Lake House - Corrections Response Letter

Building Plan Reviewer: **City of Mercer Island**

Response to: 2012-200-SUB-PLANS
Dated: April 1st, 2021
Permit #: 2012-200
Project address: 3310 97th Ave SE
Mercer Island, WA 98040

Project: Lorenzini Lake House
 Permit #: 2012-200

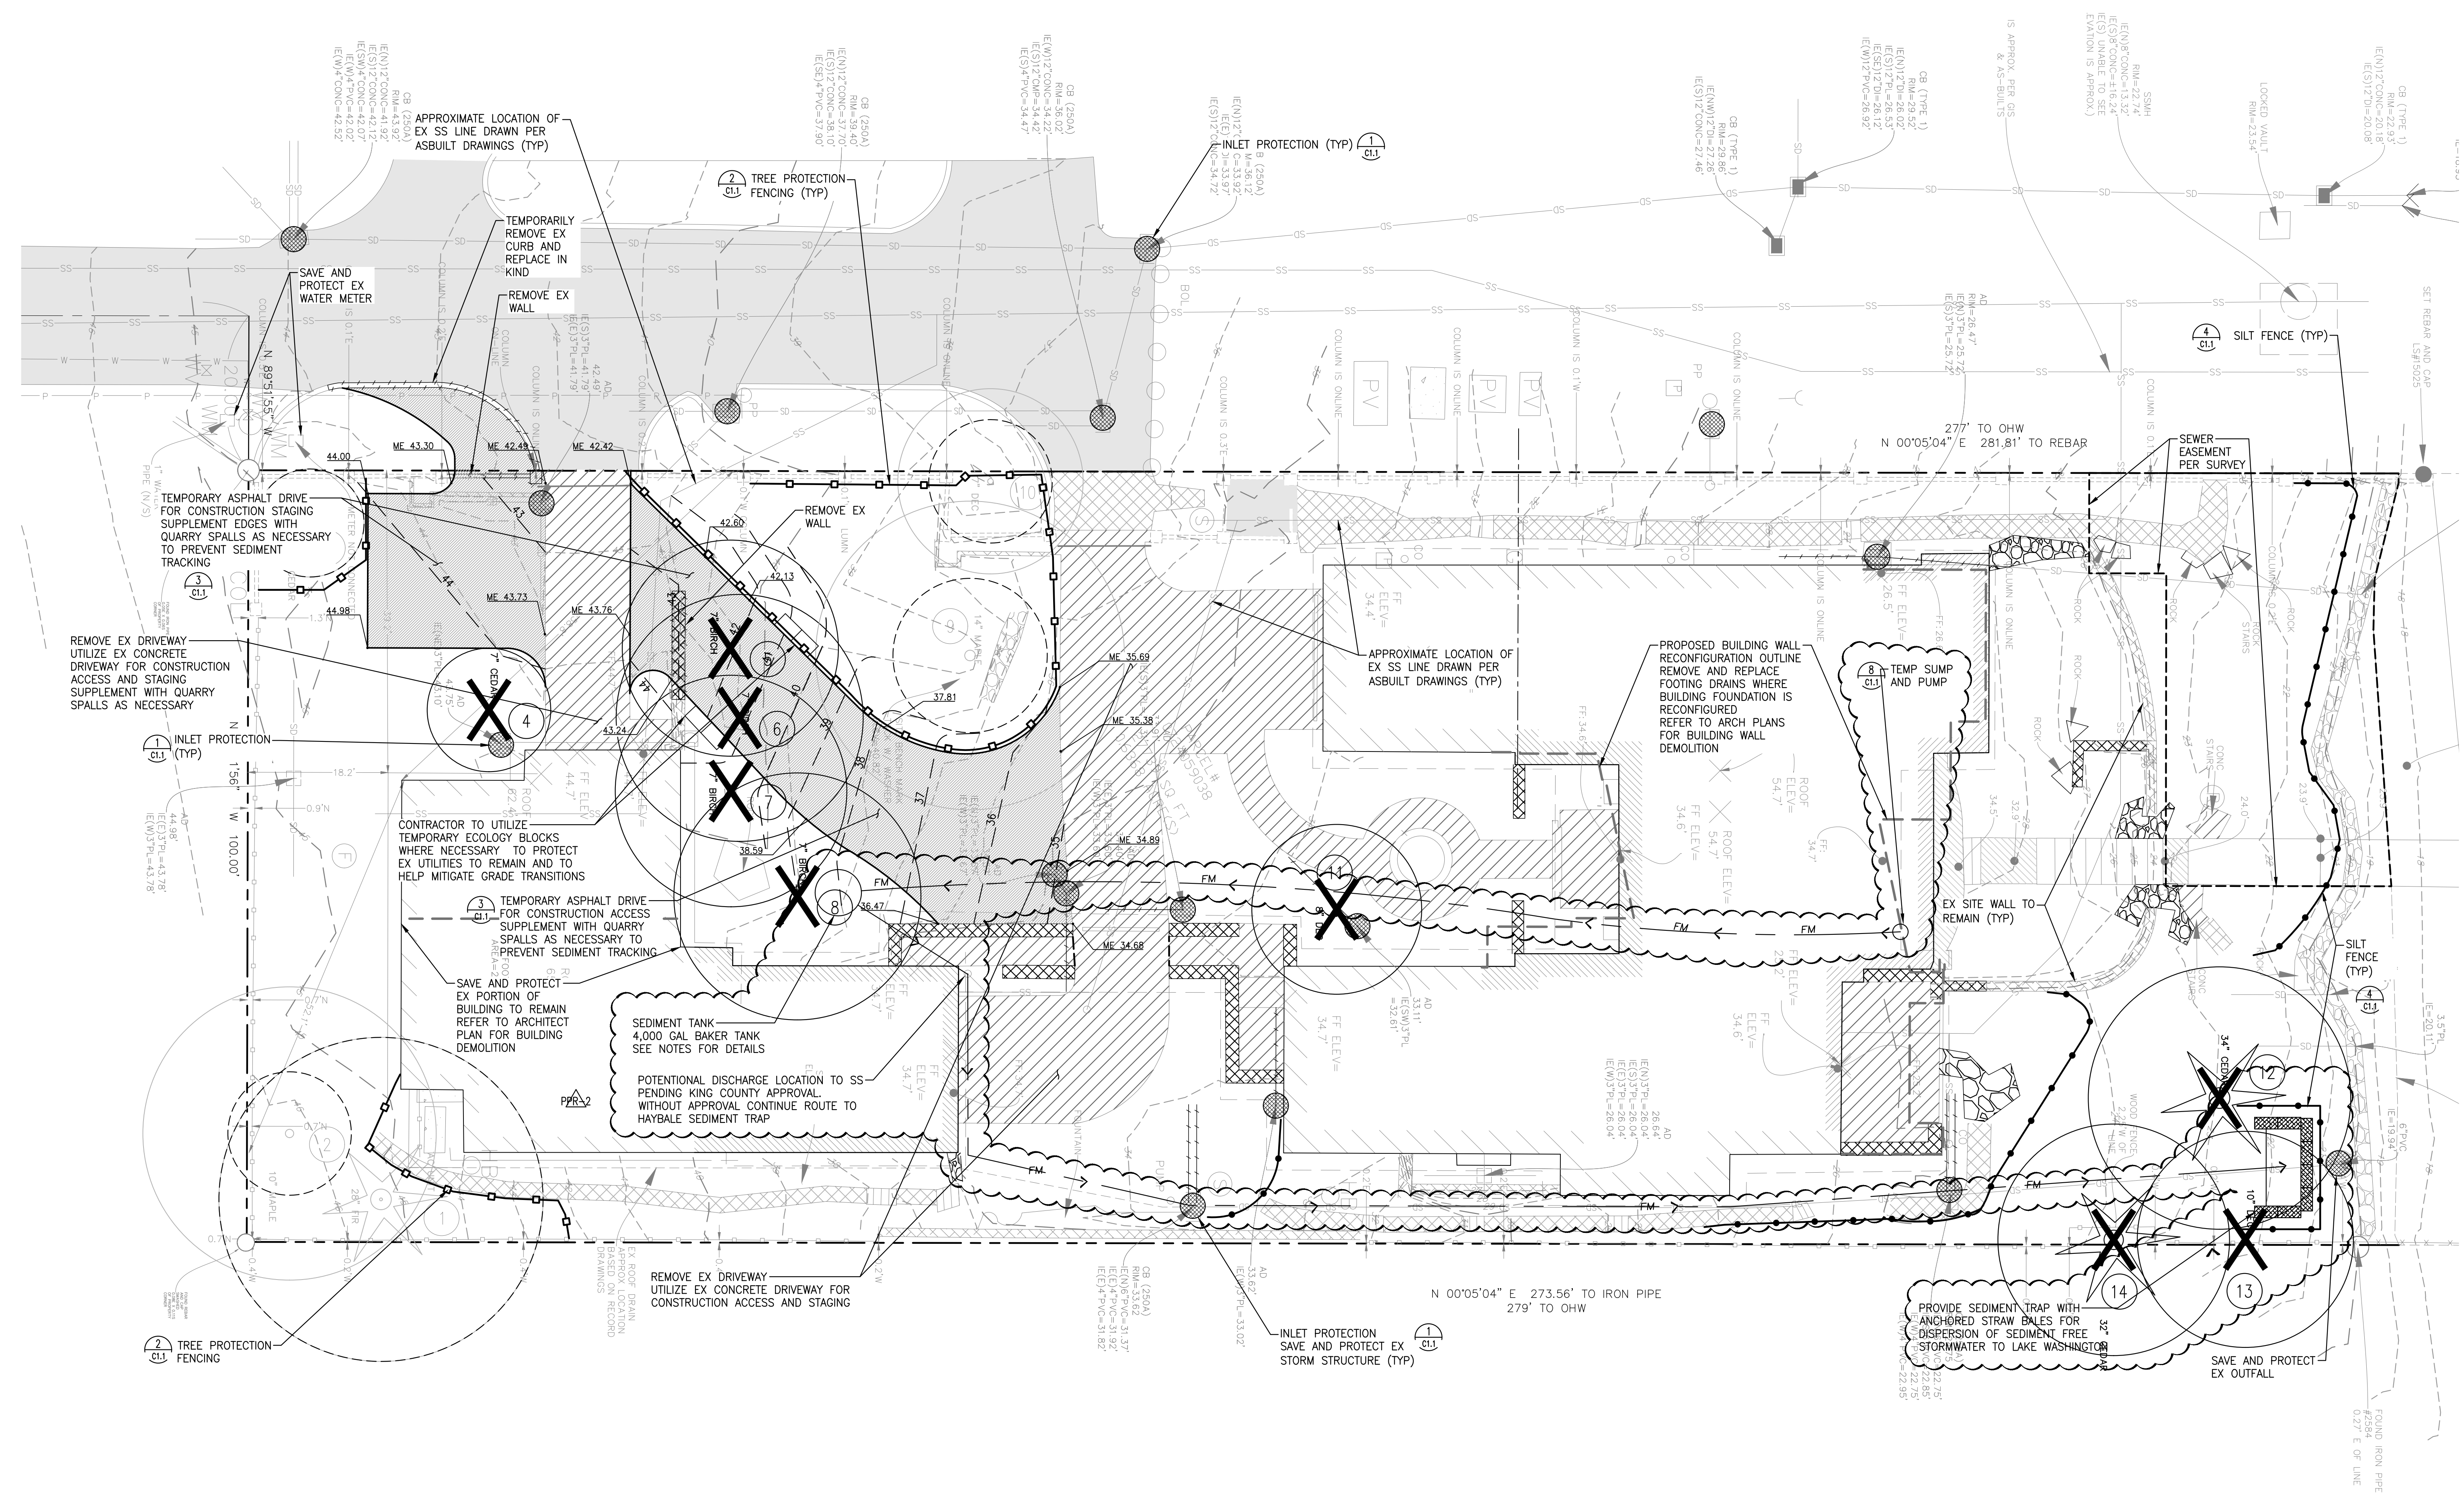
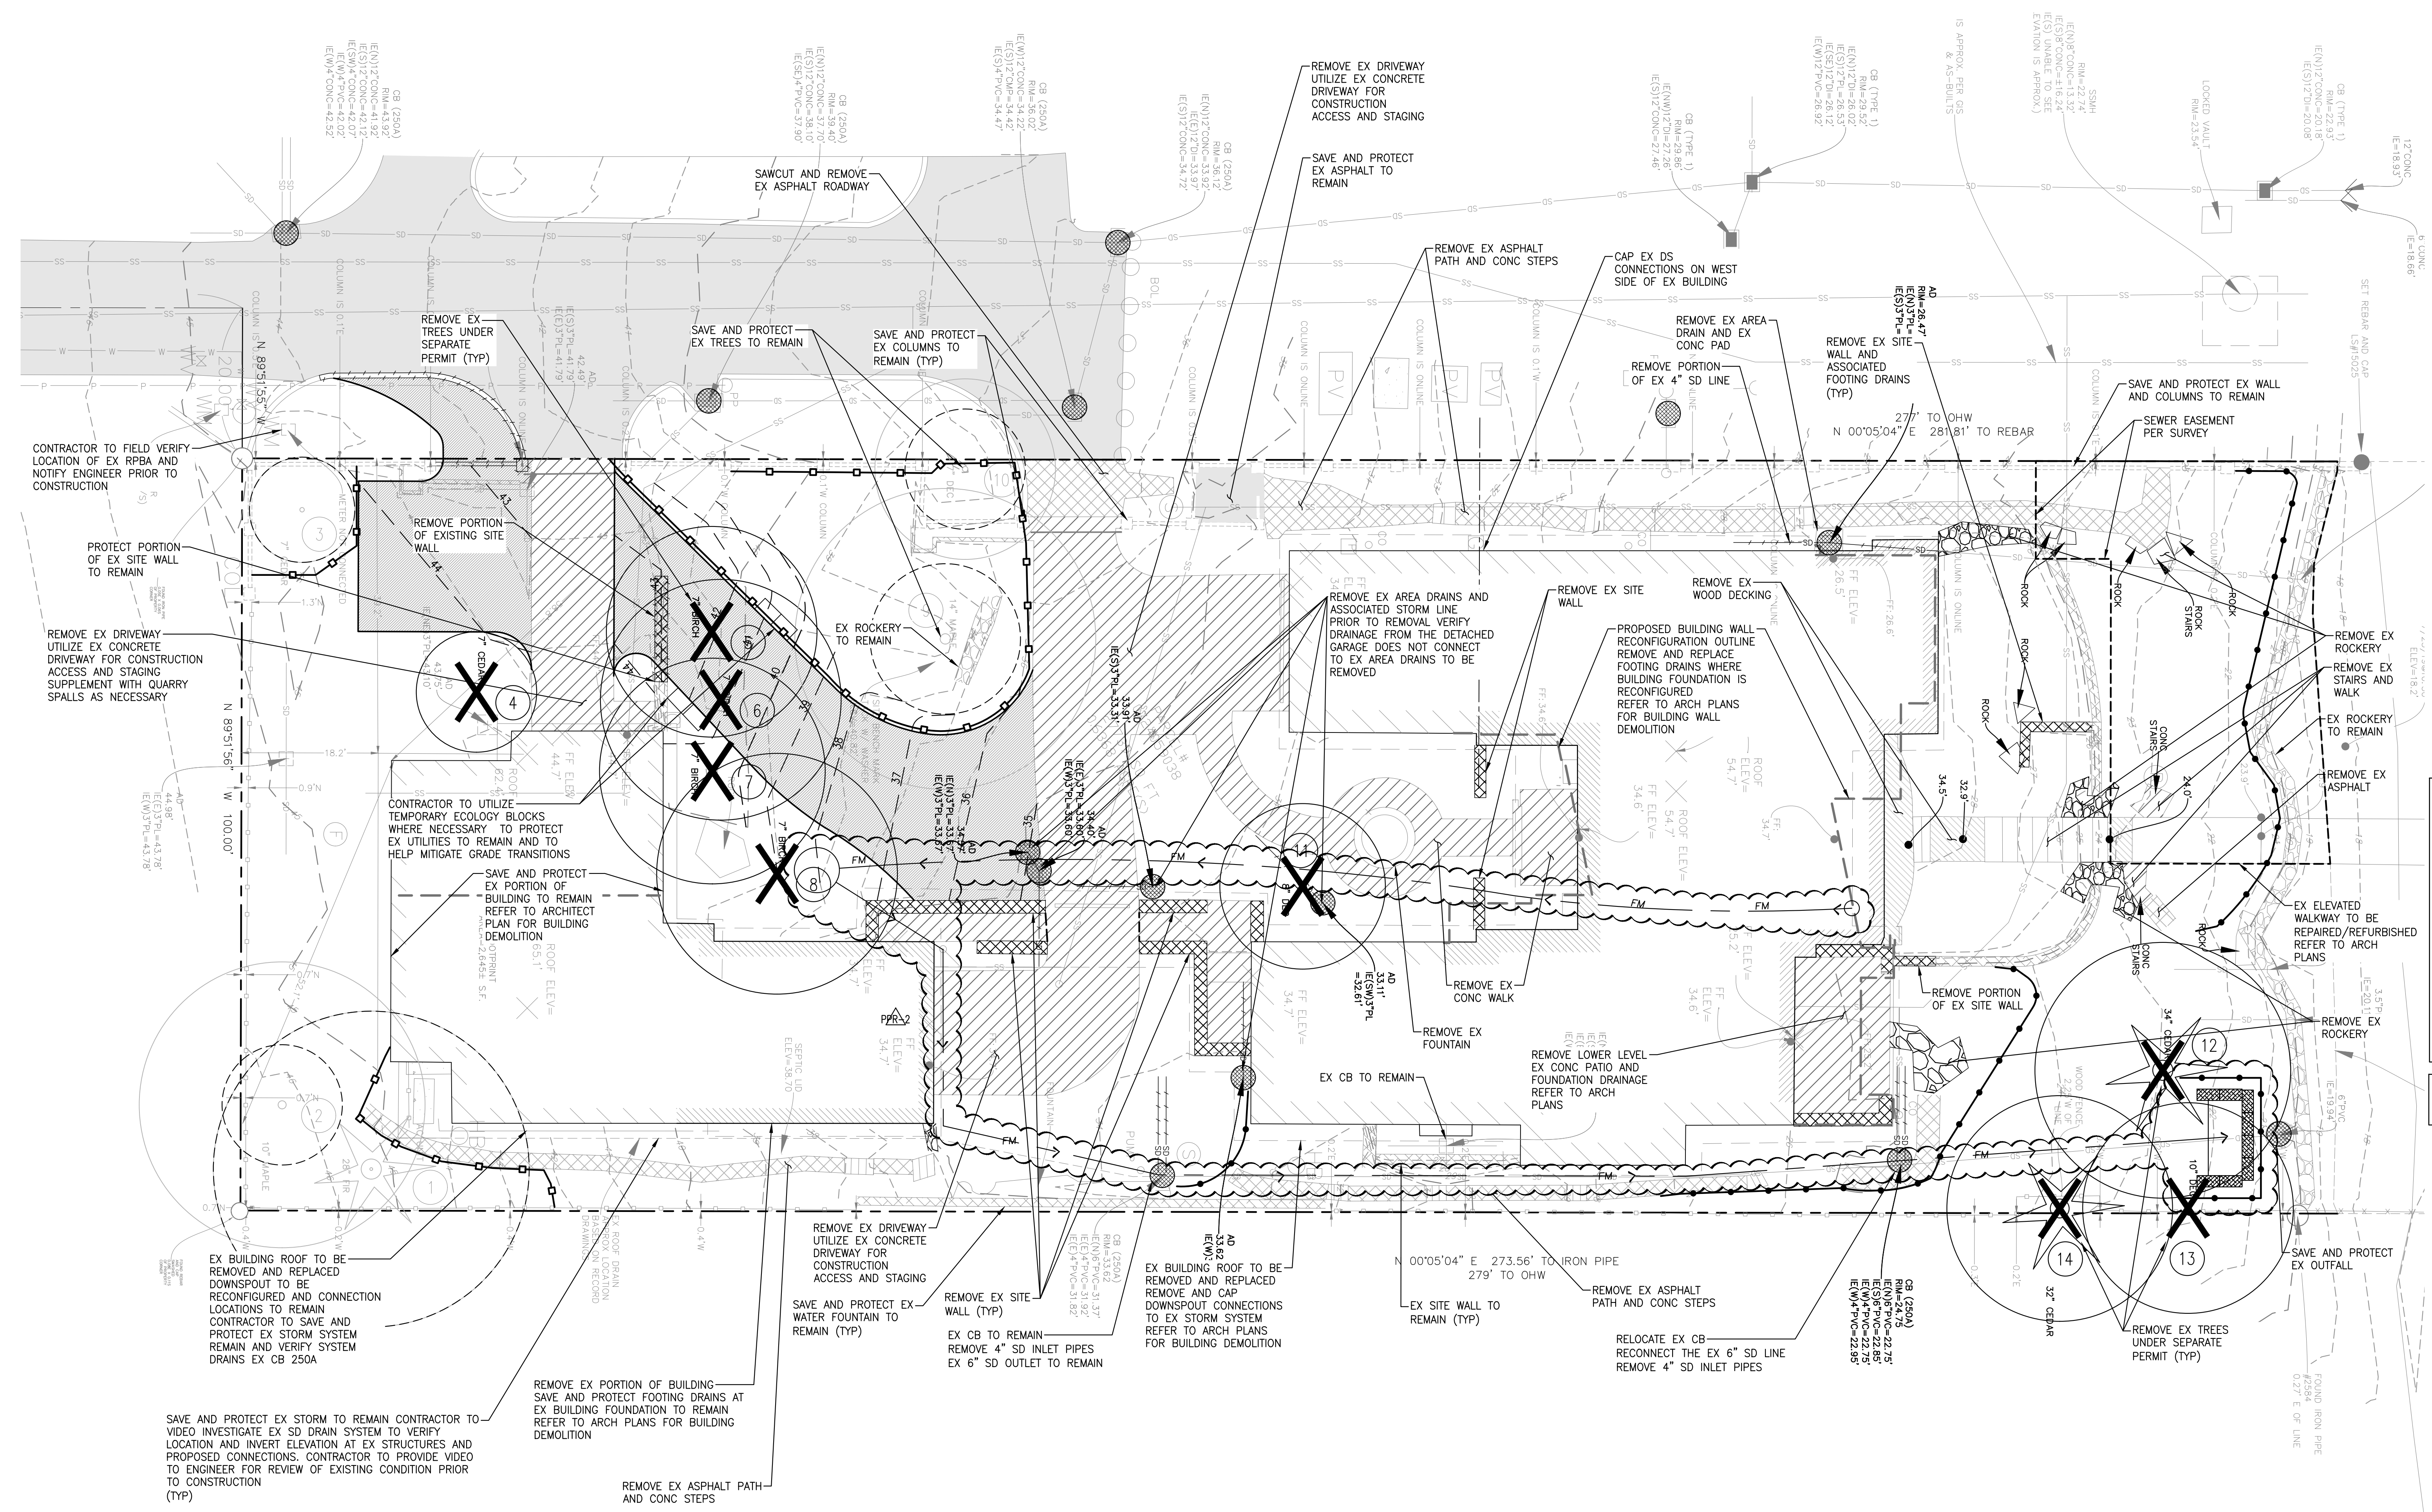
Comments –	LPD Response
<p>1. Planning Review - Page 5</p> <p>Please label and show this easement on the site plan, civil, and tree plans.</p>	<p>Sewer easement has been labeled and shown on plan sheet C1.0A TESC, C1.0B Demo, C1.0C tree retention, and C3.0 paving and utilities.</p>
<p>2. Civil Review - Page 6</p> <p>Remove fence out of ROW.</p>	<p>Tree protection fencing has been removed out of ROW.</p>
<p>3. Civil Review - Page 10</p> <p>Are you considering to use LID (previous material) to manage the runoffs for this parking area? If so, please provide design in the drainage report and plan (with detail section).</p>	<p>A detail section for the driveway pavers has been added to the plans on Detail 7 Sheet C3.1. A description of the implementation of permeable pavement in this area is included in the previously submitted drainage report.</p>
<p>4. Civil Review - Page 10</p> <p>Can you clarify the section of the existing storm pipe to remain? And add note to say that the entire existing remaining storm system must be video inspected and</p>	<p>A clarification note has been added to sheet C1.0B to save and protect existing storm as well as video inspect the system prior to</p>
